WEST SUSSEX COUNTY COUNCIL CONSULTATION

TO:	Arun District Council FAO: Maria Tomalova
FROM:	WSCC - Highways Authority
DATE:	4 January 2021
LOCATION:	Land at Rear of Poachers Eastergate Lane Chichester PO20 3SJ
SUBJECT:	BN/151/20/PL Erection of 1 No. 4 bedroom detached dwelling with detached carport (resubmission following BN/46/20/PL). This site is in CIL Zone 3 & is CIL Liable as new dwelling & is a Departure from the Development Plan.
DATE OF SITE VISIT:	n/a
RECOMMENDATION:	Advice
S106 CONTRIBUTION TOTAL:	n/a

PROPOSED SITE PLAN

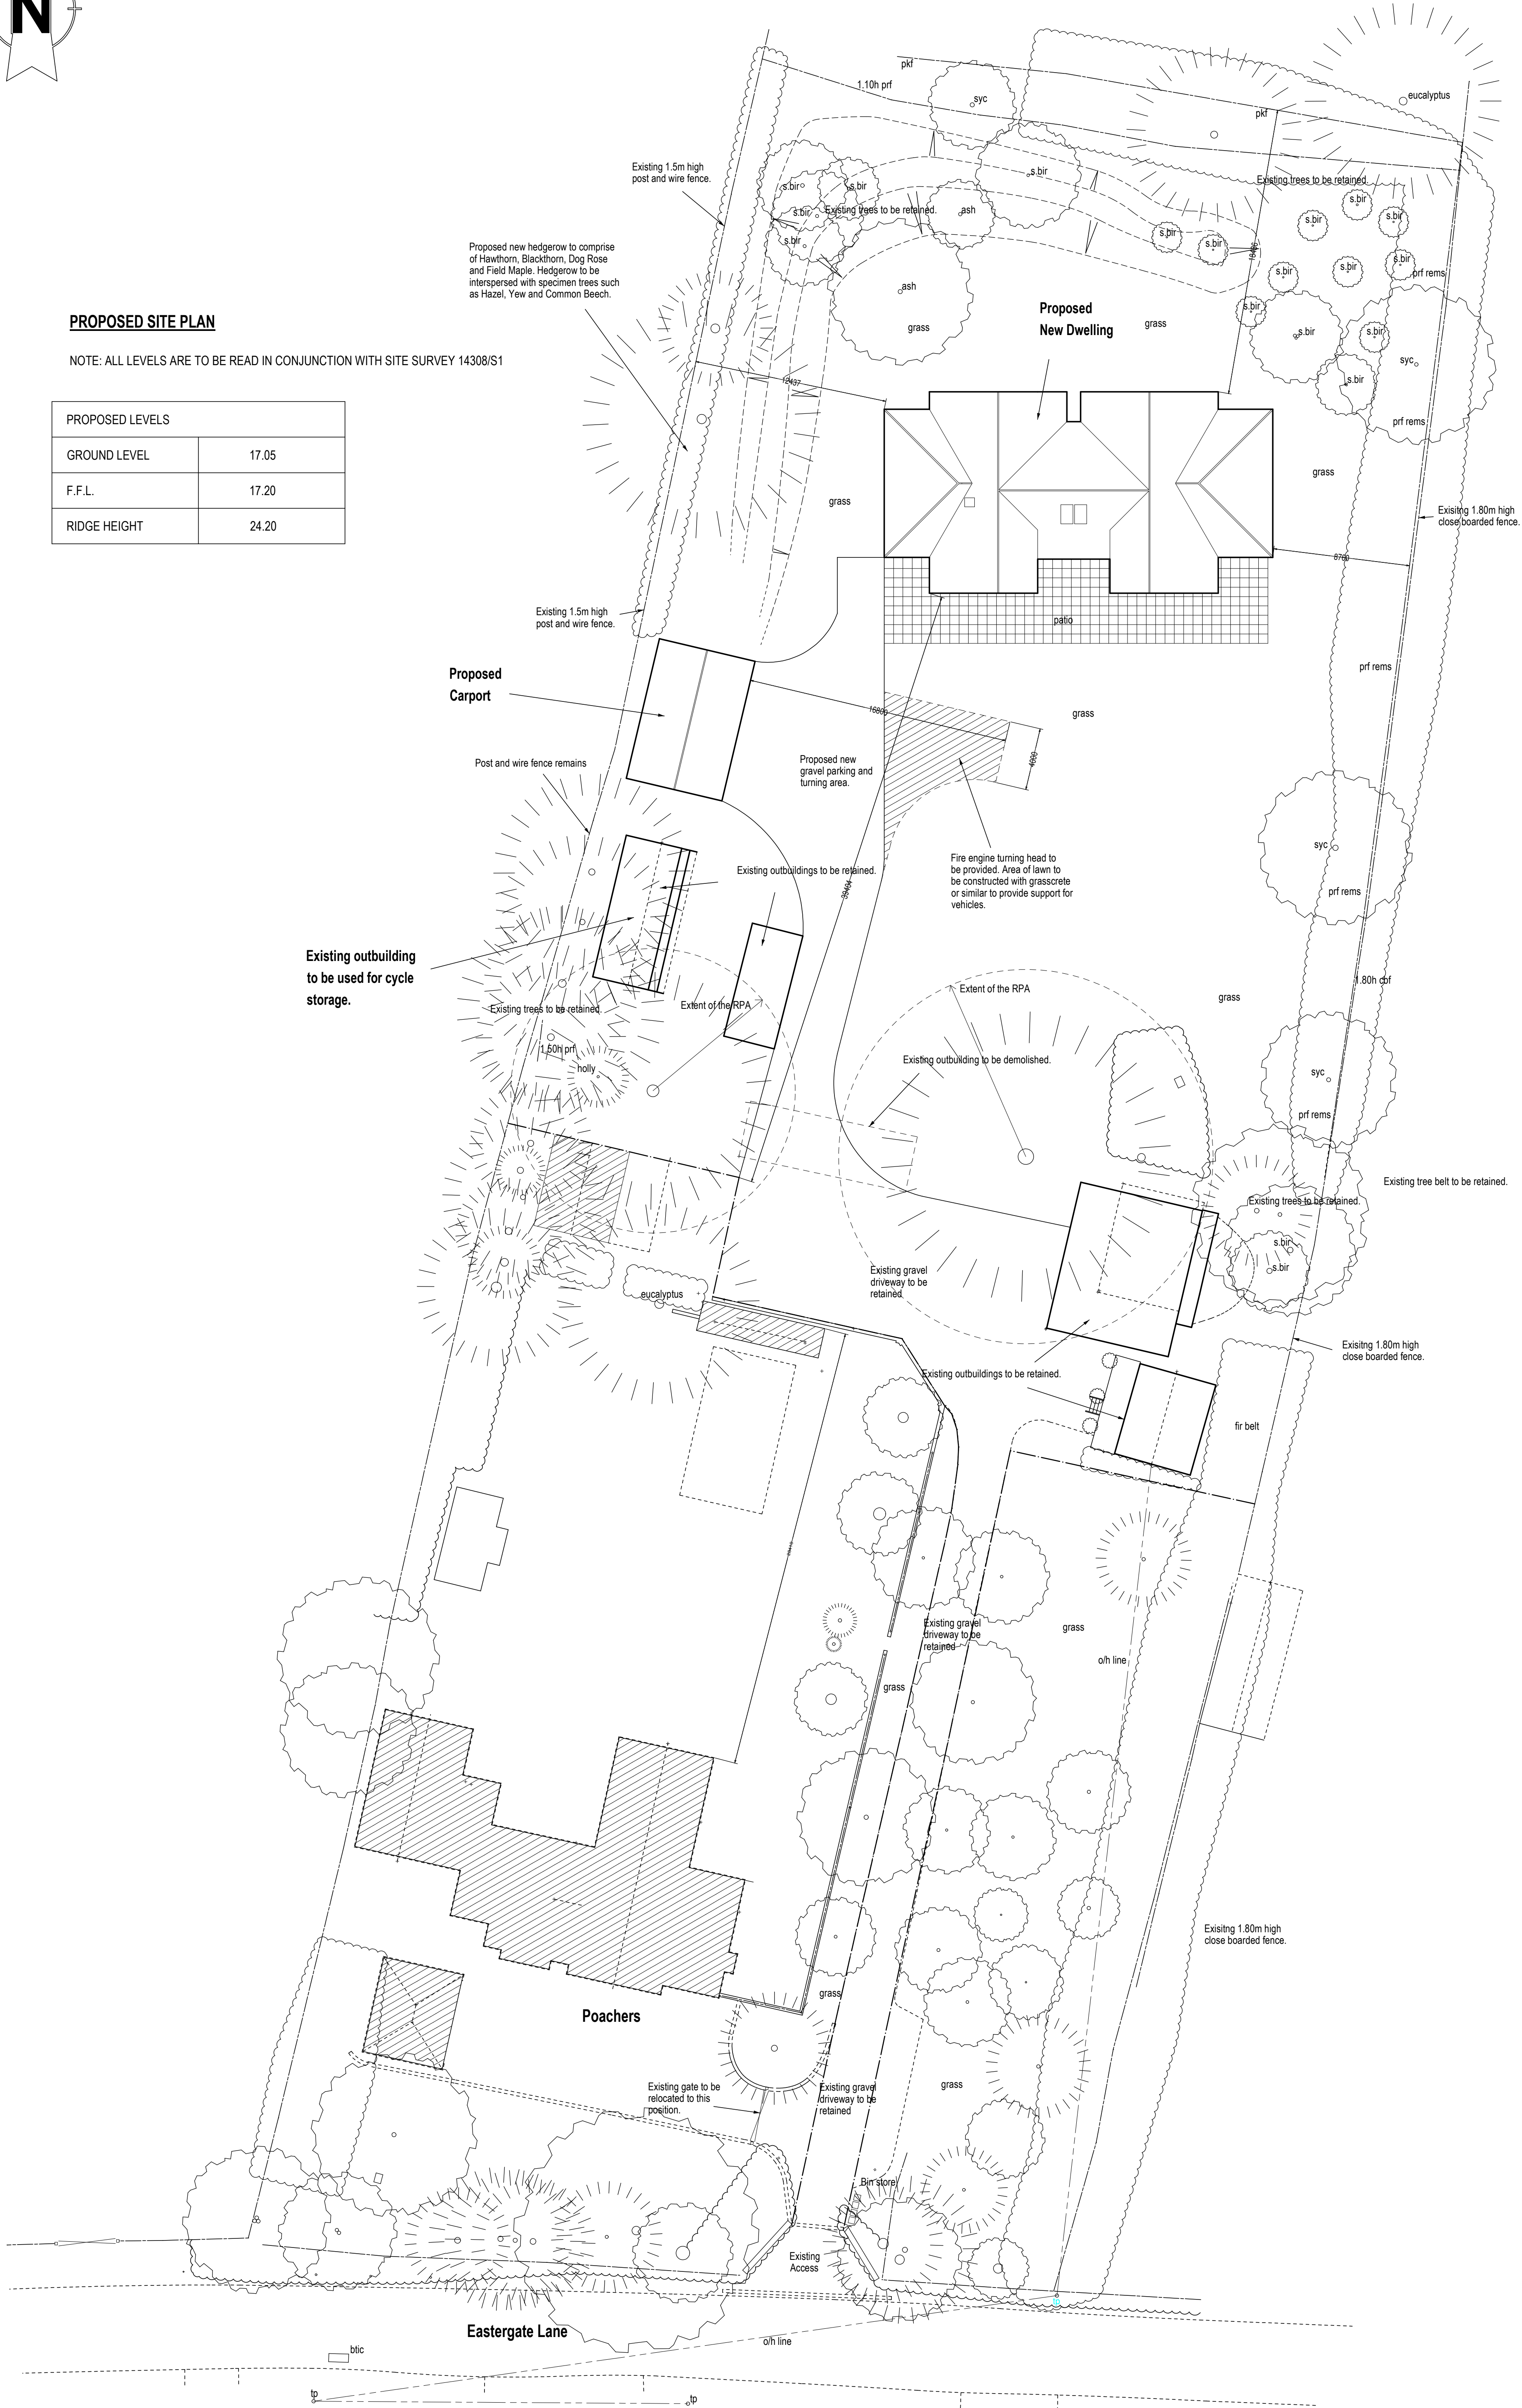
Under Arun Parking Standards (adopted January 2020), the LHA would predict that 3 parking spaces would be enough for a dwelling of this size and location.

The applicant proposes a 3-bay parking provision for the new 4-bedroom dwelling. Under the Arun Parking Standards (adopted January 2020).

The applicant has provided adequate parking to Arun standards, with hardstanding large enough to accommodate the 20% additional visitor parking.

Upon inspection of the plans and supporting documents the LHA concludes that the applicant proposes to supply a NIL parking provision. The LHA advise the following,

The LHA advises the Local Planning Authority (LPA) that if they deem cycle parking justifiable then the applicant should show this in the form of lockable covered storage. Details of which can be secured with a suitably worded condition found below.

The applicant has demonstrated a turn on site. The proposed hardstanding area has been proposed to accommodate such a provision. This conforms to Manual for Streets (MfS) Guidance of a minimum of 6 metres to the rear of any parking space.

No part of the development shall be first occupied until the car parking has been constructed in accordance with the approved site plan. These spaces shall always thereafter be kept for their designated purpose.

No part of the development shall be first occupied until covered and secure cycle parking spaces have been provided in accordance with plans and details **to be** submitted to and approved by the Local Planning Authority.

No part of the development shall be first occupied until the vehicle turning space has been constructed within the site in accordance with the approved site plan. This space shall always thereafter be kept for their designated use.
